5th May 2022

2021/0479 DEARNE VALLEY PARKWAY: RESPONSES TO CONSULTEE COMMENTS

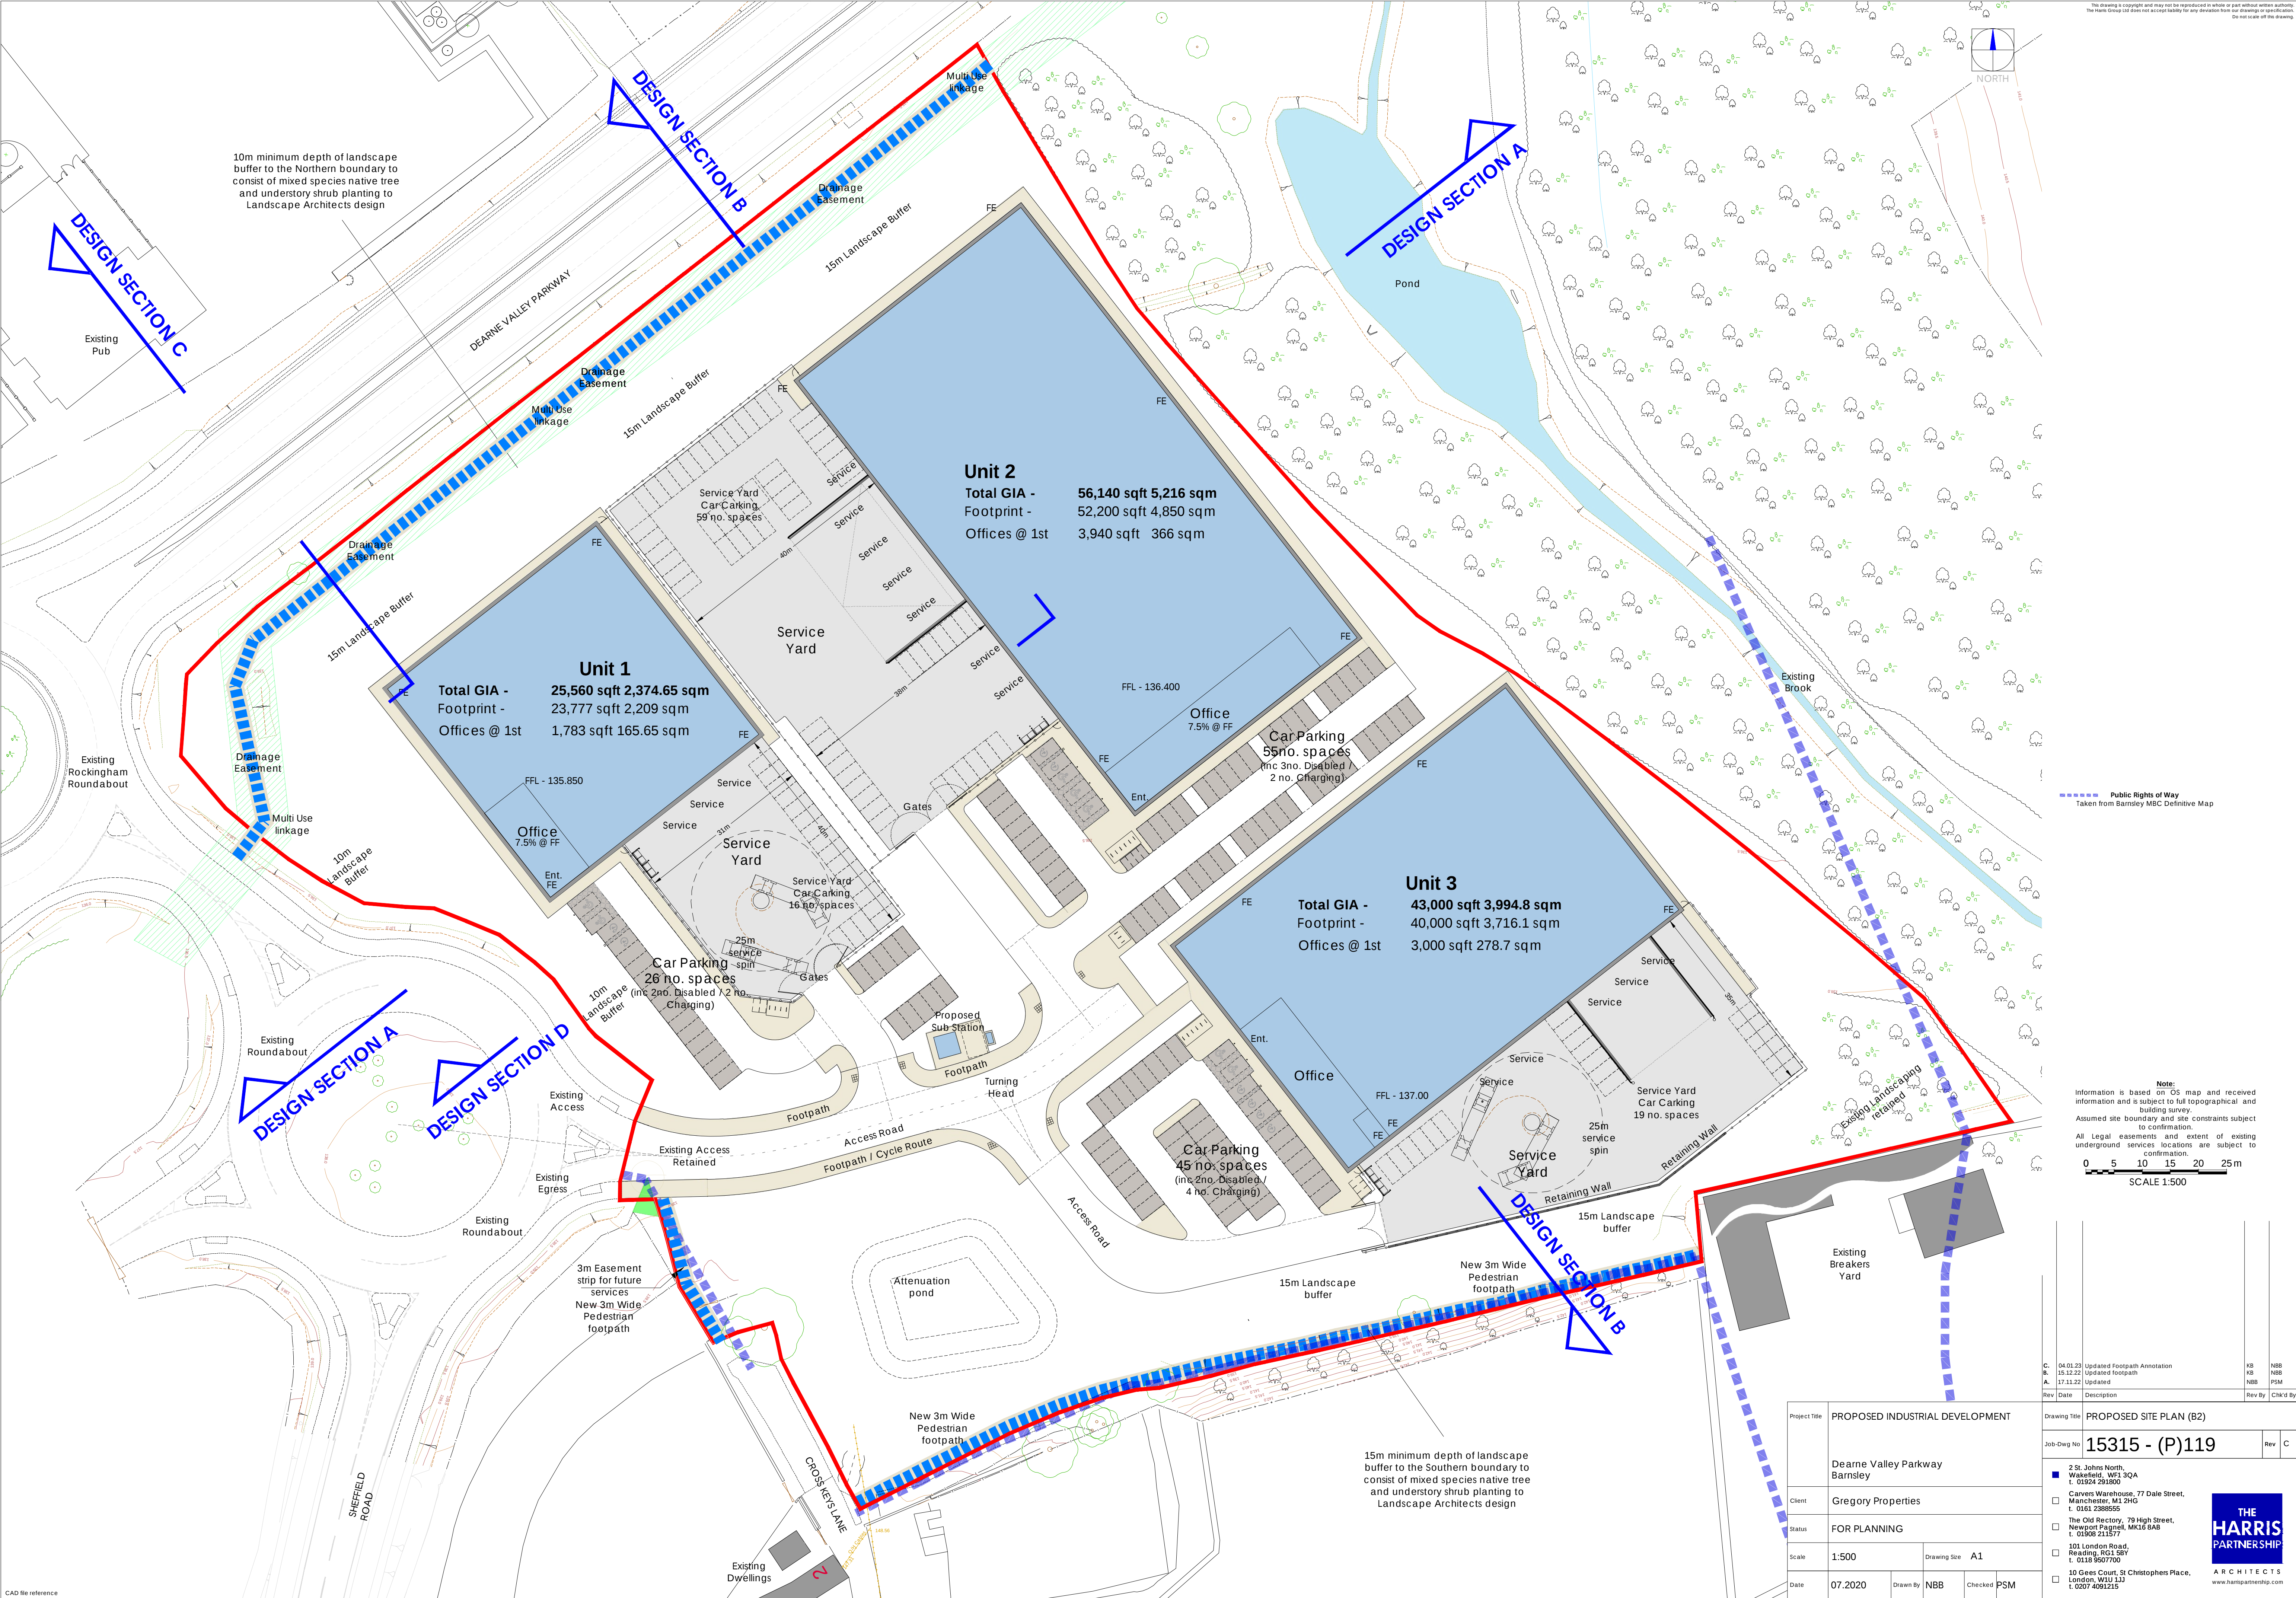
- The main footpath entering the site along the main access is now located on the northern side of the carriageway at 3 metres which will allow cyclists to enter the highway on the northern side of the carriageway rather than needing to cross it.

- The kerb line to Unit 3 access road has been modified to allow two HGV's to pass.
- A two metres wide footpath has been added to the side of unit 1 car park to assist pedestrian access to it.

- A parking bay (6m x 3.6m) has been added to the substation to meet operator requirements.
- Motorcycle parking has been added to all units.
- The Unit 1 carpark and retaining wall have been adjusted to accommodate the proposed hedge to site boundary to assist in screening the car park and service areas from the existing roundabout. (see section shown on Harris plan ref: 118)

We do now show relevant routes running to both the south (as existing) and north (to link with new proposals) which are proposed as 3 metre wide compacted crush stone to accommodate cyclists and pedestrians in a similar approach to that in neighbouring projects.
